M25 junction 28 improvement scheme

TR010029

9.116 Applicant's comments on Jane Allan's Deadline 7 submission

June 2021

Project Title	M25 junction 28 improvement scheme
Drawing Title	DESIGNATED FUNDS - NMU ROUTE BROOK STREET ROUNDABOUT
Drawing Number	HE551519
Project	J28
Originator	ATK
Volume	HGN
Type	DR
Role	CX
Number	00001
Original Size	A1
Scale	1:500
Project Ref. No.	5158157
Sheet	1 of 1
Rev.	C02

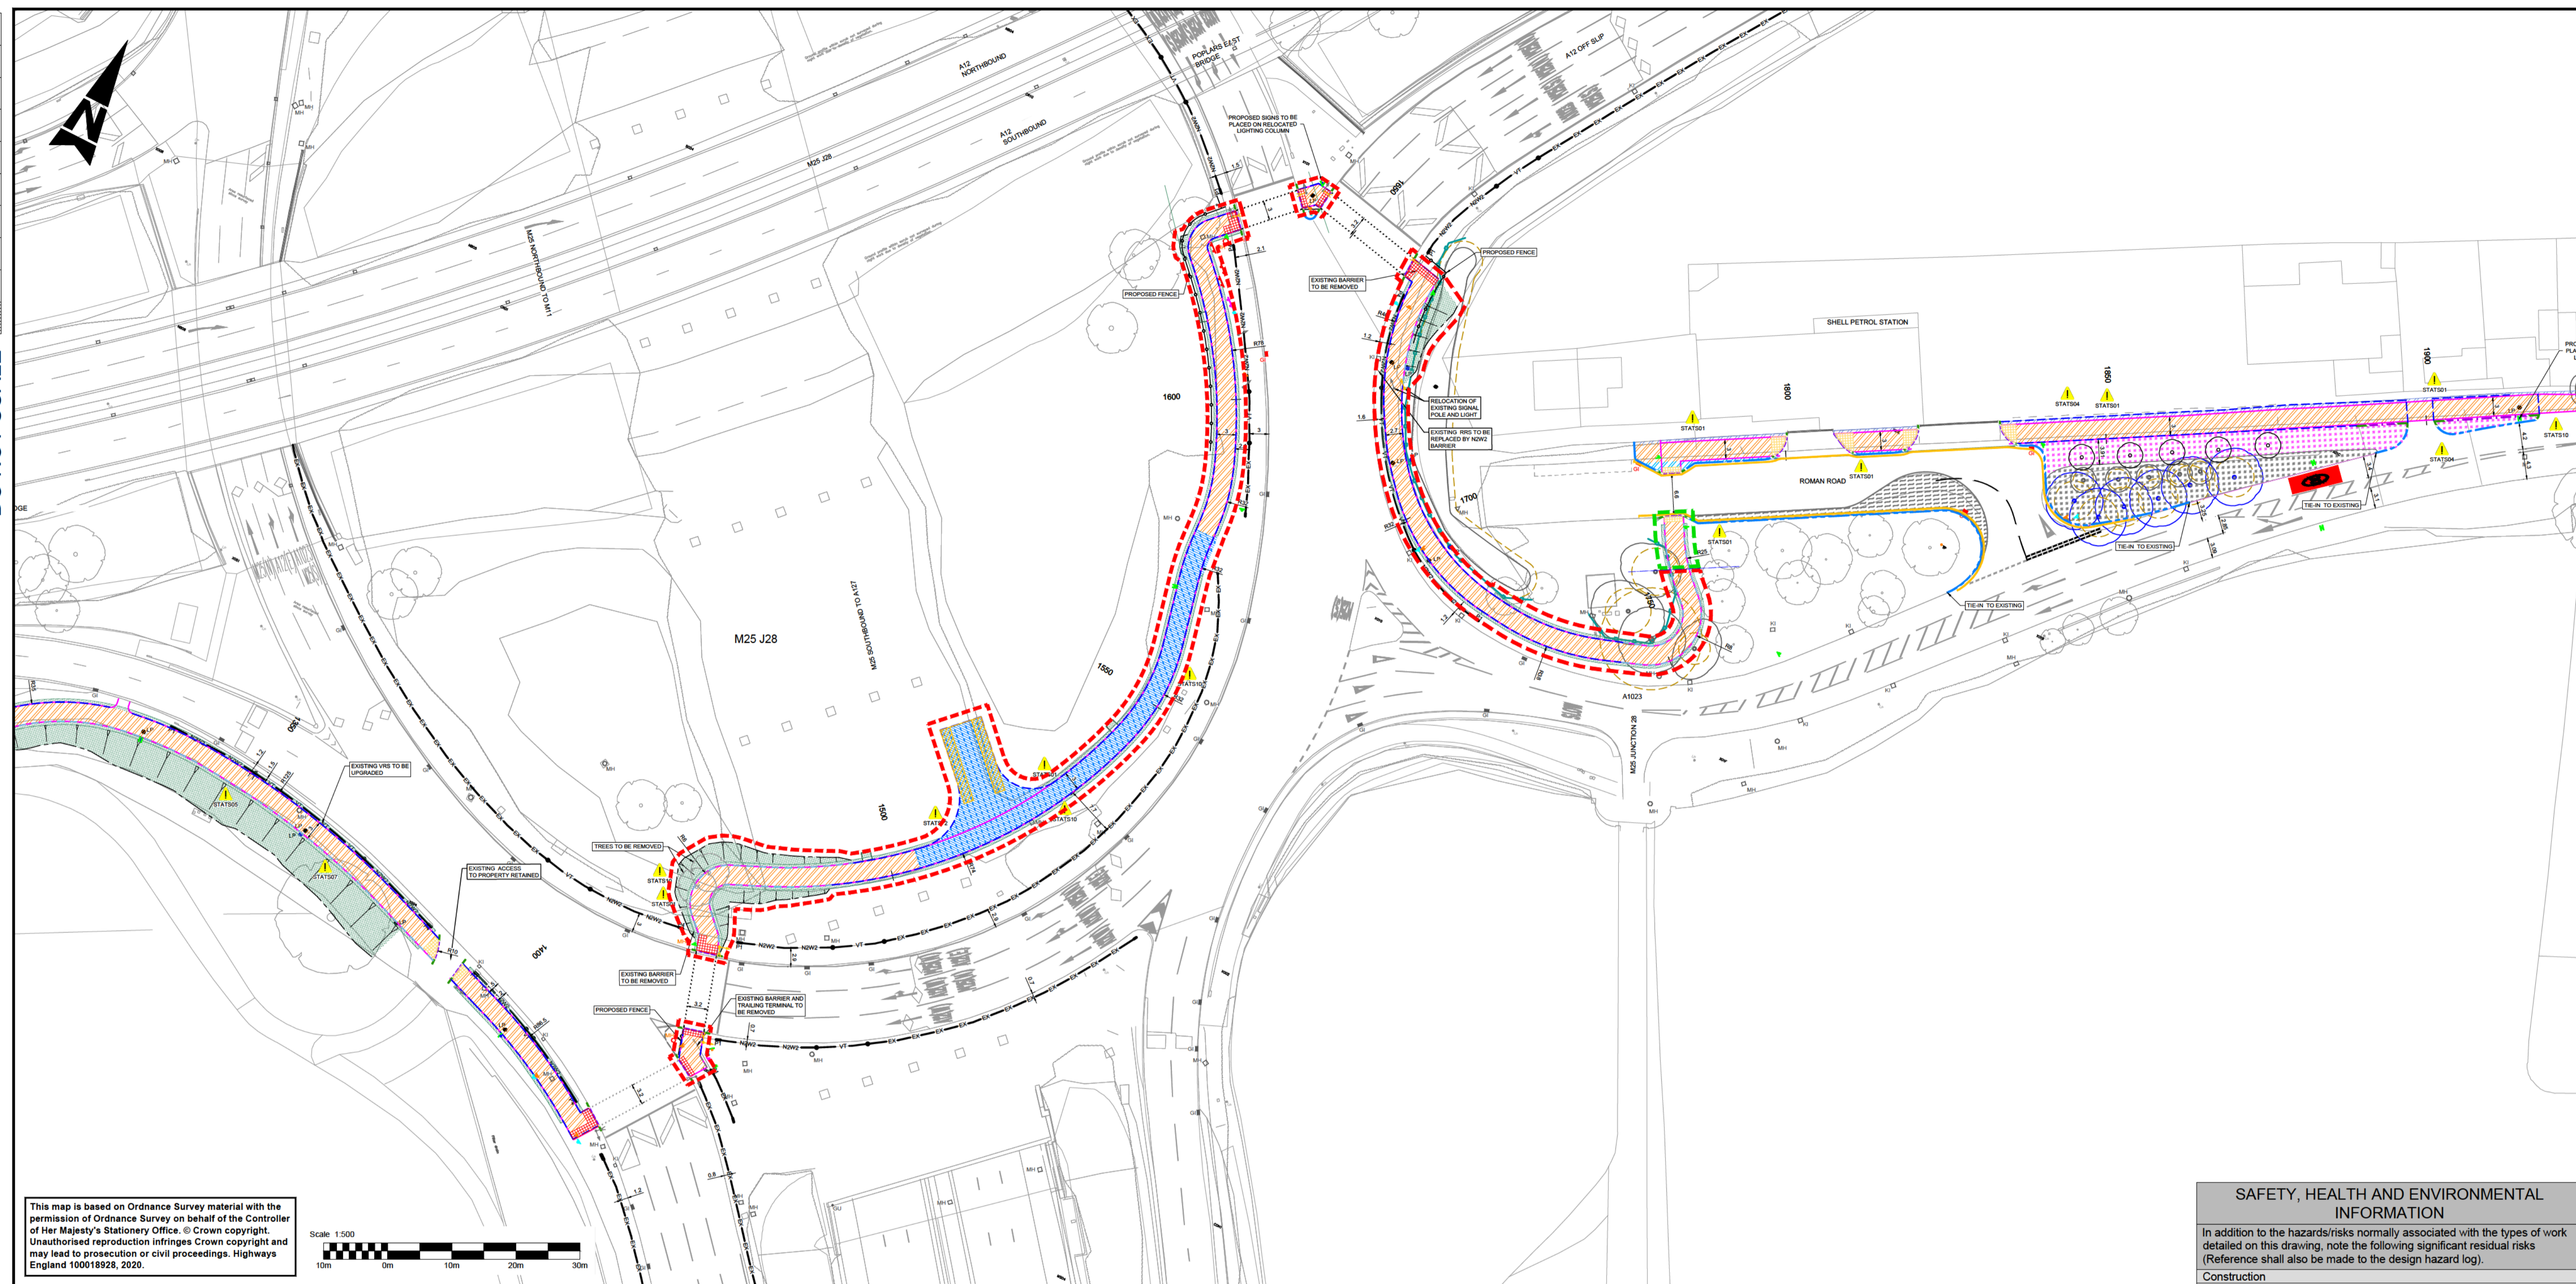
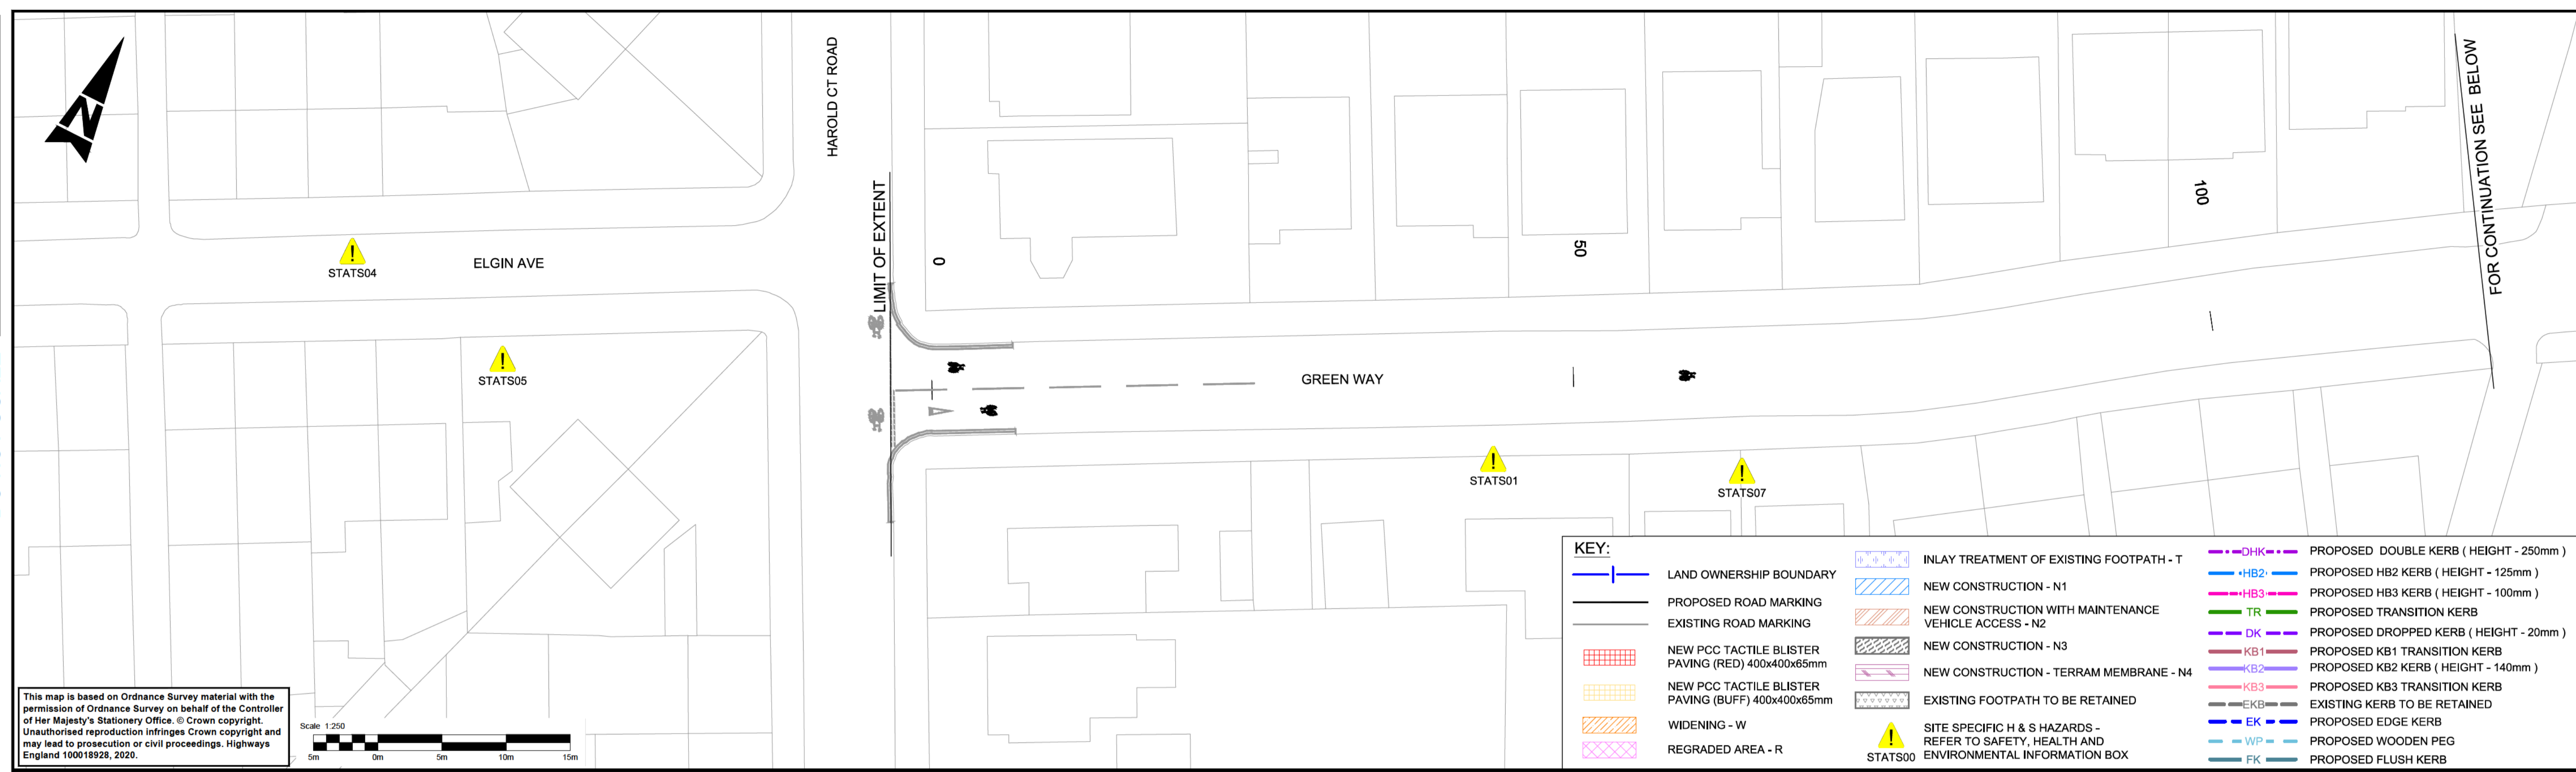
Response reference:	Representation Issue	Highways England Response
REP7-040-01	<p>Following the meeting I have the following issues/concerns:</p> <p>1. Please clarify if consultation with local residents has occurred on the proposed NMU Designated Funds Scheme in this area? I do not recall seeing or hearing any information about this scheme. The proposed scheme predominantly improves accessibility on the A12 southbound carriageway and does not meet the needs of residents on the northbound A12 carriageway. I would expect local residents to be fully consulted prior to any decisions being made on such an important scheme with a budget of @ £3.5 million? If funding for NMUs was from the M25j28 project (not the NMU Designated Funds Scheme) would the consultation process be different? The whole area (northbound and southbound of the A12) needs upgrading for NMUs (and 498 bus stops) with improved pathways, barriers and safe crossing areas on both sides of the A12. The suggested A12 subway crossing point close to Petersfield Avenue is renowned for attracting unsociable behaviour and finding abandoned burnt out bikes, burnt walls, smashed lights and other waste matter- because of this, I, like other residents in the area, do not use the subway as a regular crossing point and resort to</p>	<p>Please refer to Highways England's response to Action Point 1 of the Issue Specific Hearing 3 (ISH3) response document (REP7-019).</p> <p>In ISH3 Highways England explained that in developing the designated funds scheme, various alternative options were examined to improve accessibility for non-motorised users (NMUs) between Brentwood and Harold Hill. These alternatives included options along the northern side of the A12 carriageway as well as the southern side of the A12 carriageway. As a result of this process Highways England took the view that on balance the option along the southern side performed best in terms of catering for the needs of NMU users including local residents, design feasibility, safety for NMUs, and value for money. In the ISH3 hearing Highways England explained that the southern option makes use of the existing subway on the A12 adjacent to Petersfield Avenue, approximately 100m from Woodstock Avenue. This subway is of a good standard and forms part of the national cycle network route 136 (NCN136) to facilitate the safe and convenient crossing of the A12. As such Highways England's position is that this route option on the southern side of the A12, with its connection to the NCN136 at the subway, would improve accessibility considerably and is the safest route for NMUs between the eastern and western sides of the M25 motorway.</p>

Response reference:	Representation Issue	Highways England Response
	crossing the A12 at nearby non pedestrian controlled traffic lights.	The existing footway facility on the northern side of the A12, including the eastbound off slip road, would remain, albeit replaced as part of the reconstruction of the slip road. This route would continue to be available for pedestrians (it would not be a shared use path) but the NMU scheme offers a safe and convenient alternative for the vast majority of NMU users.
REP7-040-02	<p>2. The outline TMP does not meet the needs of residents in Woodstock Avenue (WA). As previously highlighted on multiple occasions in writing and verbally it is unacceptable to expect residents of WA to make diversions to the Shenfield junction along the A12 to travel westbound when the A12 off slip is closed during the construction phase of this project. In addition to the temporary (not defined) A12 off slip road closures other proposed diversions and delivery of construction materials throughout this project will impact residents of WA significantly more than other residents in this area which is why the TMP should facilitate the inclusion of a right hand turn between WA and the M25j28 off slip.</p> <p>This project will create a significant amount of disruption (noise, dust, vibration, traffic etc) for all local residents but more-so for residents of WA because of its locality issues. I believe tolerance levels of all disruptive aspects of this project would be significantly improved for residents of WA if we were able to avoid the Brook Street roundabout altogether during the construction phase and avoid having</p>	<p>Highways England recognises that temporary overnight closures of the A12 eastbound off-slip will result in Woodstock Avenue residents having to make a diversion via A12 junction 12 to the east because there is no right turn from Woodstock Avenue on the A12. The amended Outline TMP submitted at Deadline 7 (REP7-017) references this as a key challenge in Section 1.3. It is for this reason that the temporary closures of the off-slip will be kept to the absolute minimum practicable and will only be in place overnight in order to minimise disruption (<u>not</u> during peak travel times in the day). A few overnight closures of the A12 eastbound off-slip are unavoidable for some construction activities to be undertaken safely. As the closures would only be overnight, the diversion route via A12 junction 12 is anticipated to add only an additional 10 to 15 minutes to journey times because typically traffic volumes are significantly lower at night and no traffic congestion is expected during the proposed hours of closure (that is between 22:00 and 05:30 hours).</p> <p>The Scheme is forecast to result in a minimal change in traffic flows on the A12, and therefore there is no expectation that this will exacerbate any historic severance issues along the A12 during construction or operation.</p>
